Land at Drove Lane, Yapton
Surface Water Drainage Statement Addendum

(Document ref. 133647-SWDS-01C)

This updated addendum is to be read in conjunction with Document Reference: 133647-SWDS-01A and all relevant drawings to support the reserved matters application for the development site at Drove Lane, Yapton.

Permeable Paving Connection Detail To Proposed Surface Water Network

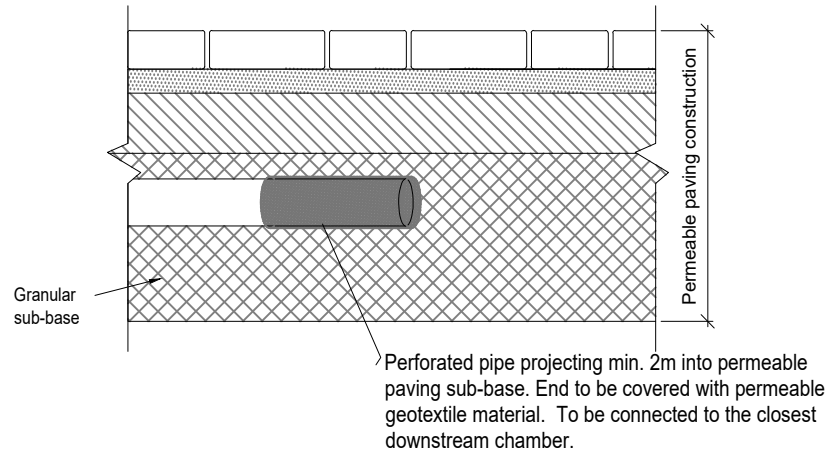
- A typical detail to show the connection of permeable paving into the drainage network has been provided with the updated application.

Drawing No.	Rev.
PLN_1_4205	B

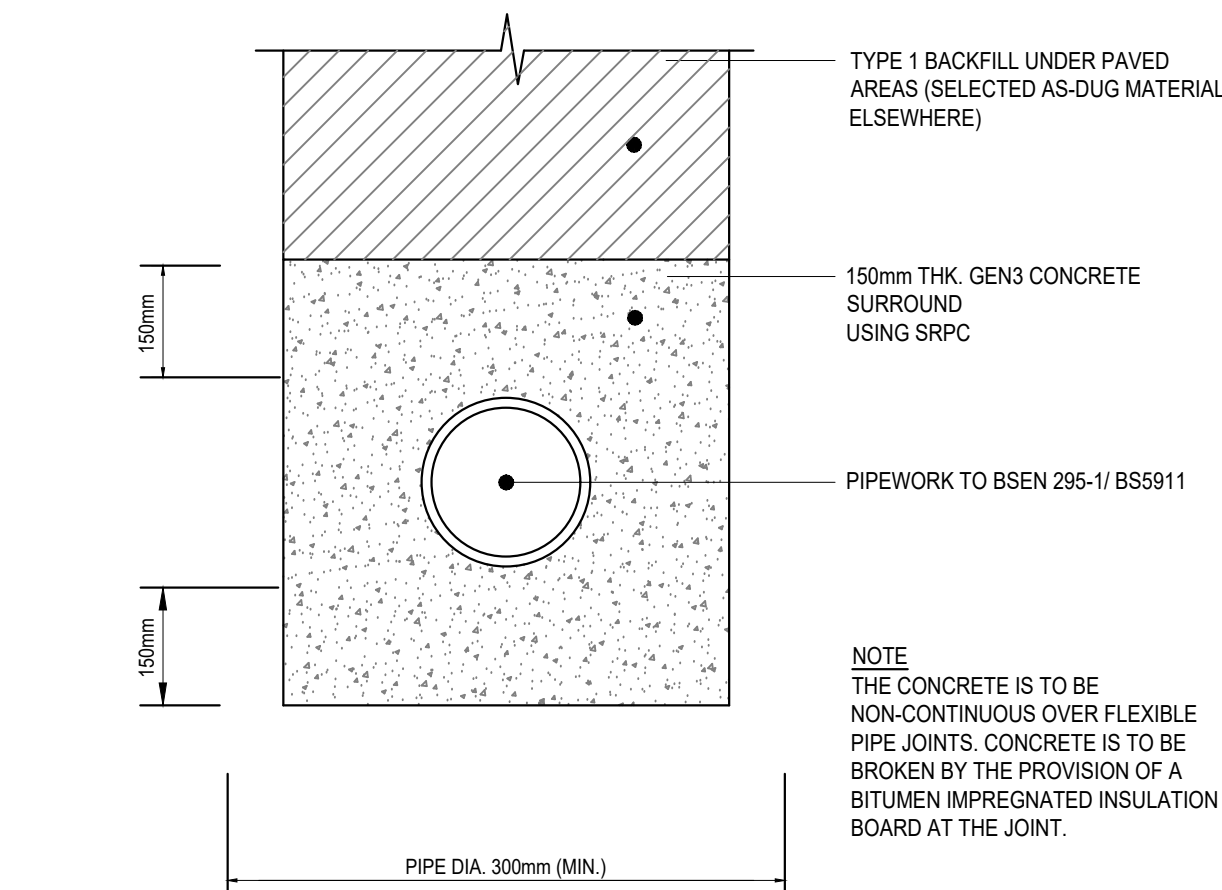
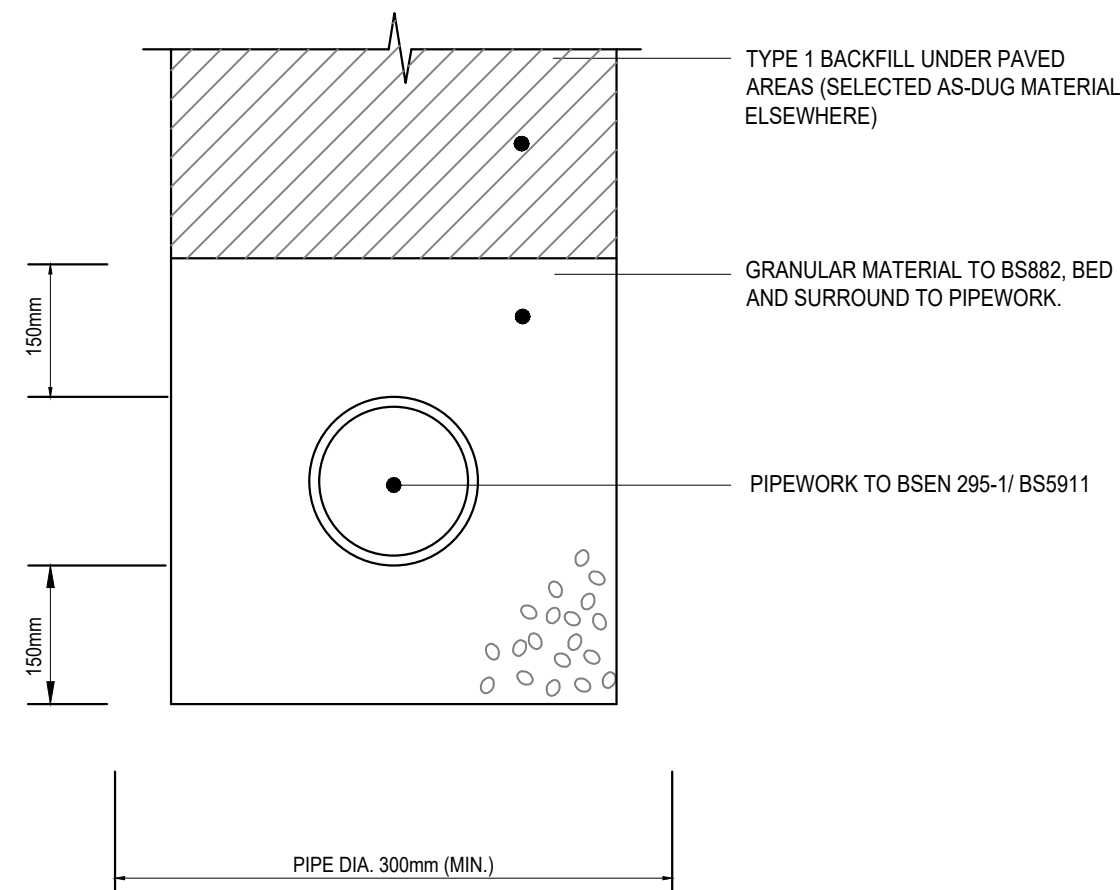
- Hydrobrake references have been added to all units on the plans.
- The drawings have been reviewed to remove inconsistencies between the plans and calculations.

- Orifice details have been added to the drainage construction details.
- Pond 2 is not lined. All features that are below the worst case ground water level from the winter monitoring have sufficient permeability to allow water to ingress and egress.

ENHANCED SWALE 5 SETTING
OUT AND DETAILS
SHEET 4 OF 4

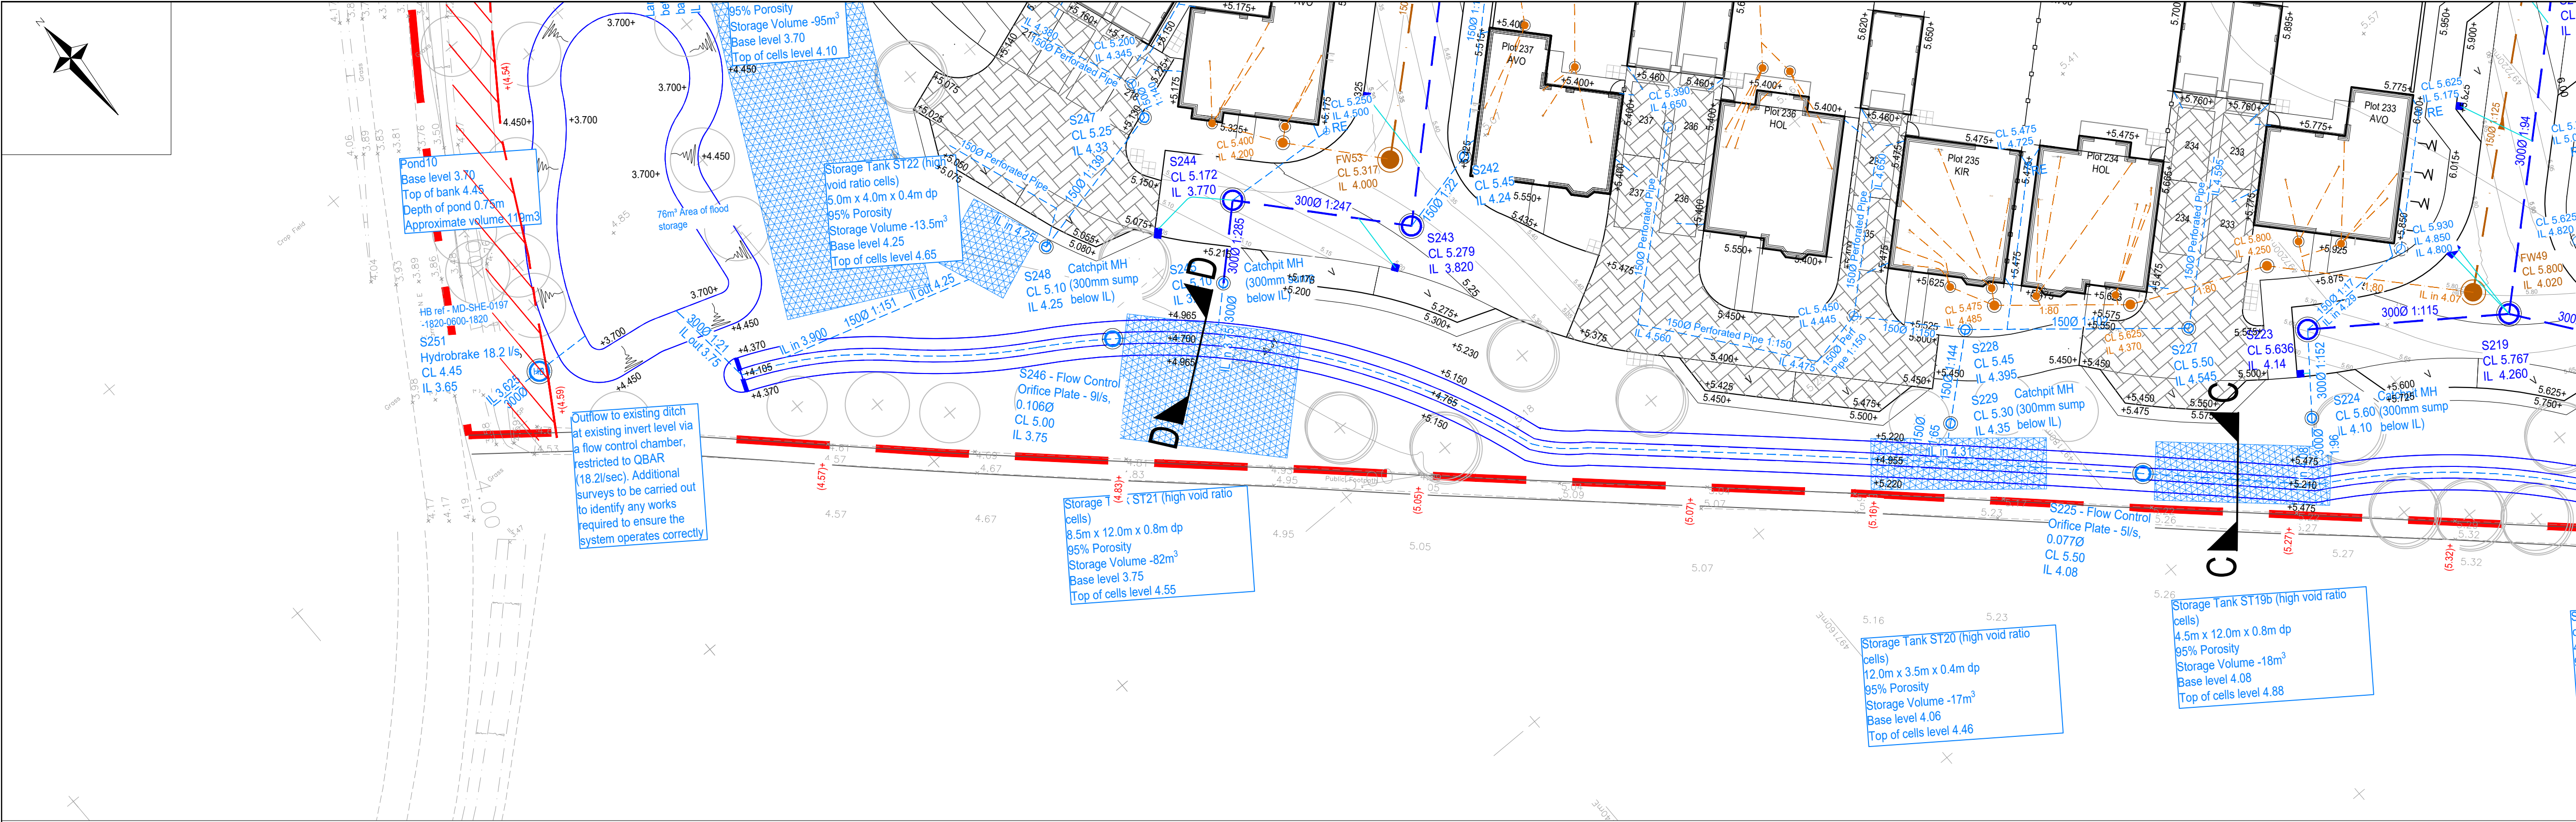
- We include construction details of the swales with references to the swales on plan.
- We include details of all drainage features employed in the drainage network.

- With the swales and cellular storage being of the same construction, we agreed to provide one representative construction detail for the enhanced swales and one for the cells. We have also provided construction details for each SuDS feature scenario encountered on this site.

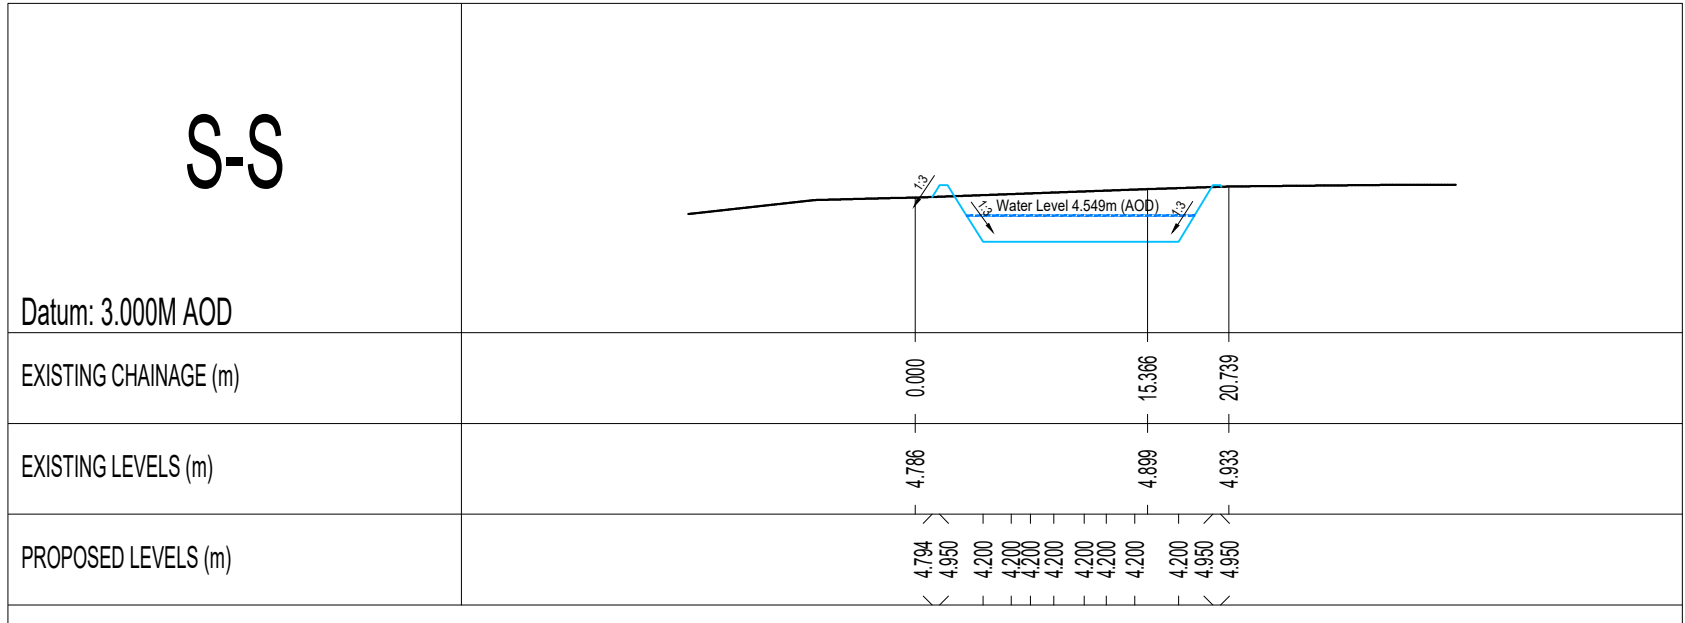
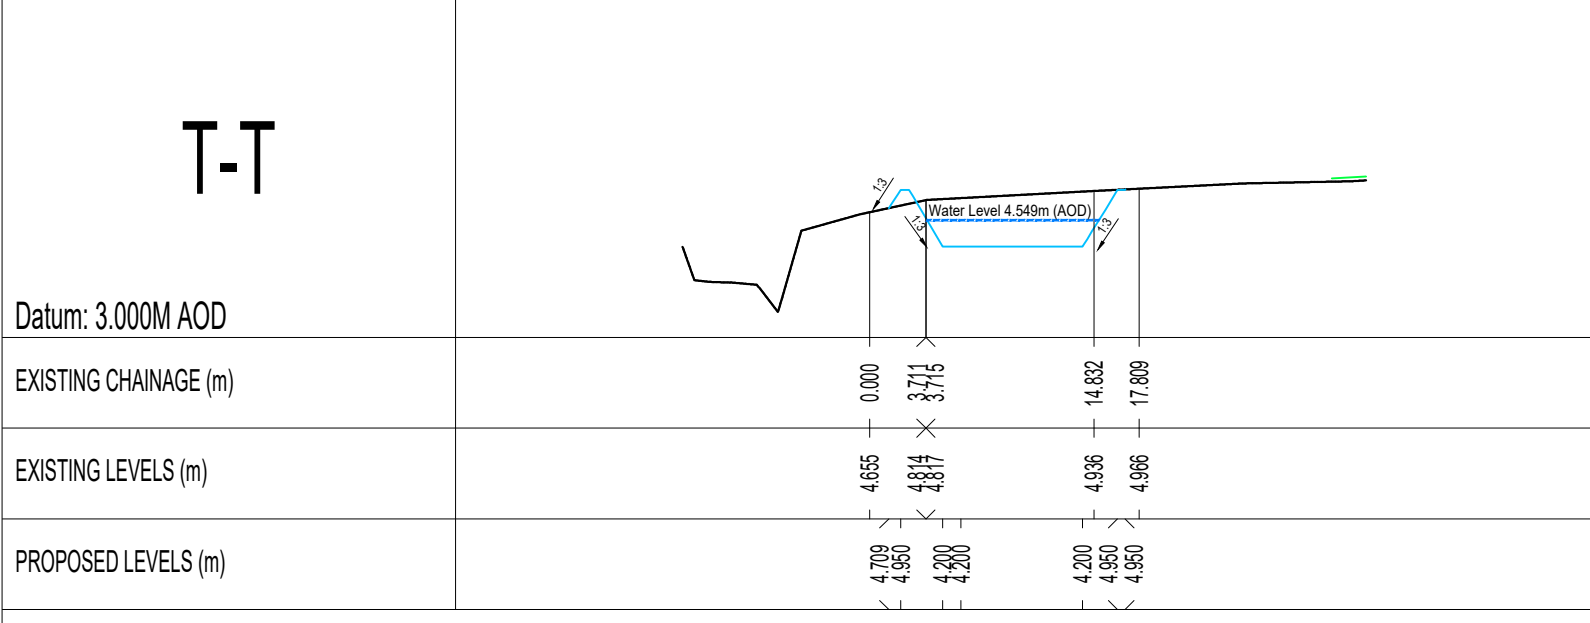
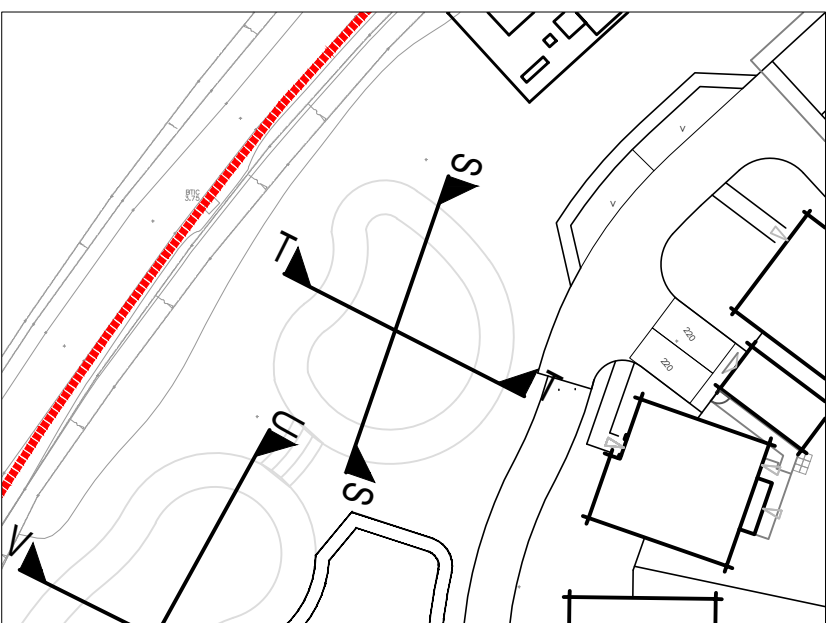
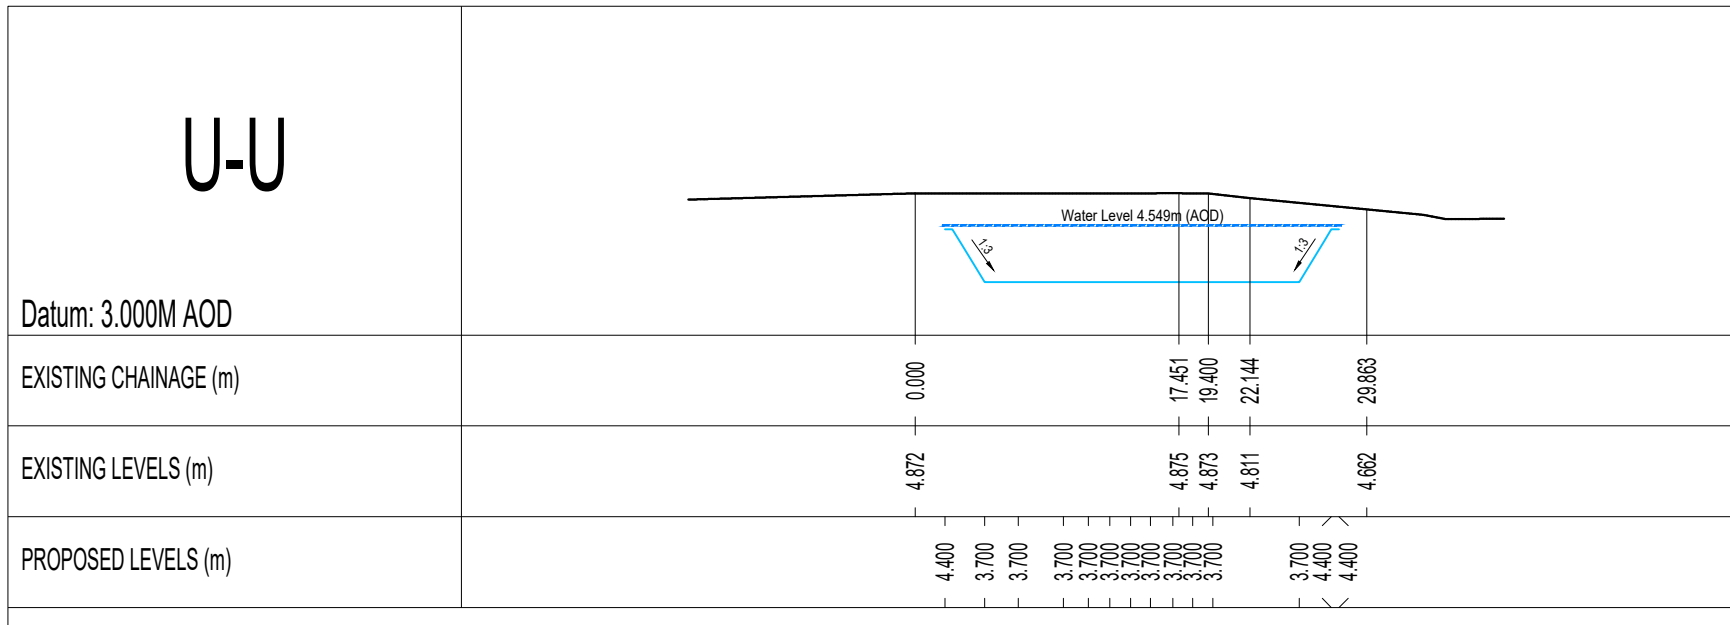
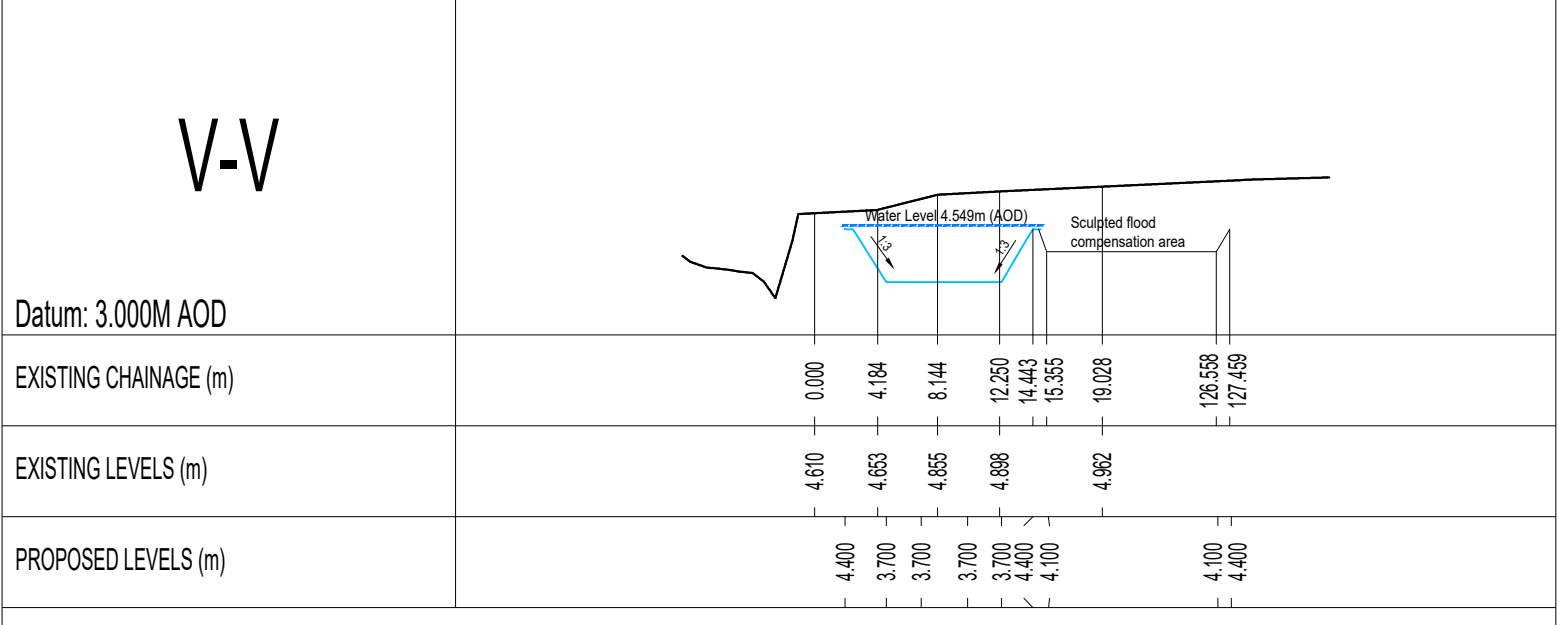
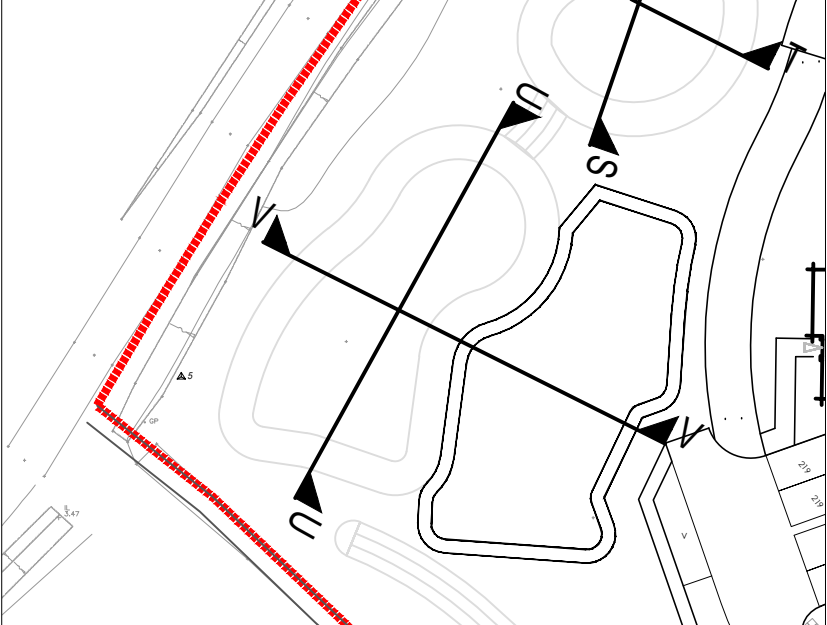
- The connection to the water course is now shown.
- Chainages are shown on the sections for the SuDS features, we do indicate the berms, top and bottom of bank, maximum water level and freeboard. Please refer to the specific SuDS details for material and crates beneath the ponds. They are drafted at a clearer scale to show the increased level of detail.

- Two cross sections in perpendicular directions through each SuDS pond have been issued with the updated application. The contractor will be provided with setting out coordinates and levels to ensure that the ponds are constructed with correct bed, bank and side slopes at the construction stage.
